From: Longridge Town Council <clerk@longridge-tc.gov.uk>
Sent: 11 May 2017 19:35
To: planning
Cc: 'Lesley'; 'Longridge Town Council'
Subject: Planning Application Comments

3/2017/0207 Davis Street - Cllr Rainford declared an interest

PROPOSED SITE PLAN

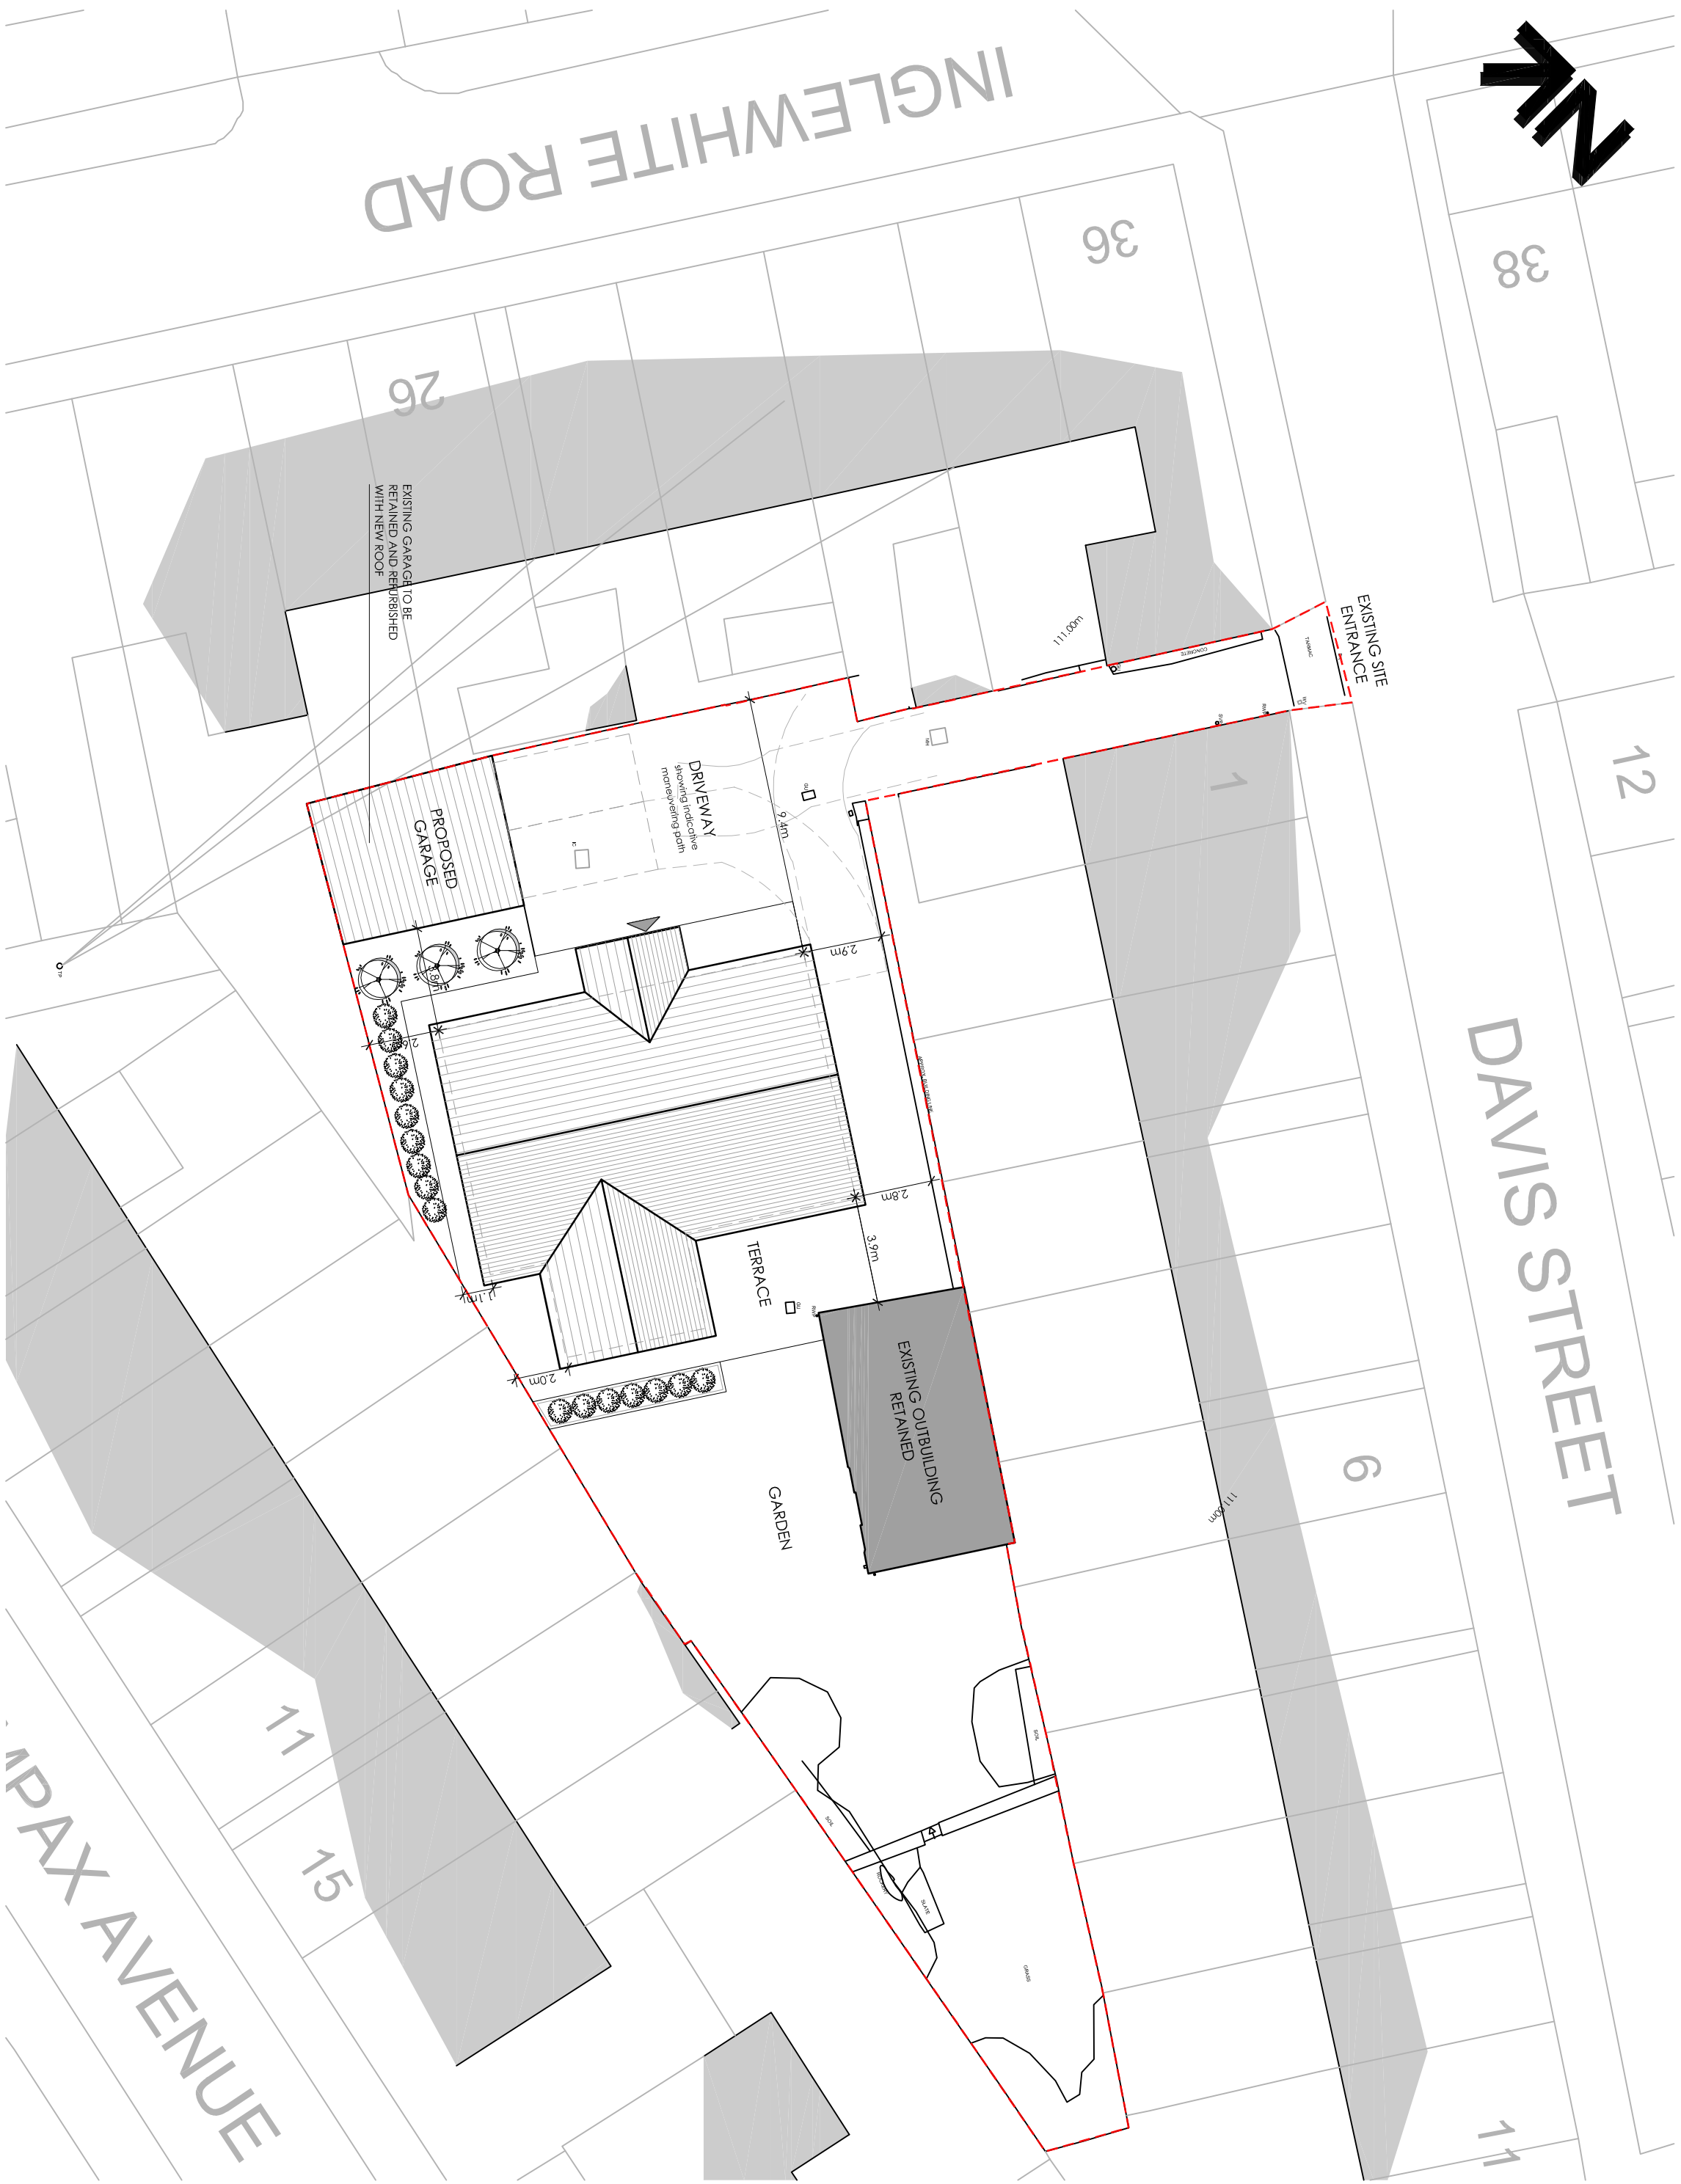
LTC - observation drawn to RVBC's attention that there will be a loss of parking which it believes will cause additional issues locally. It has also been brought to LTC's attention that a sewer runs through this land.
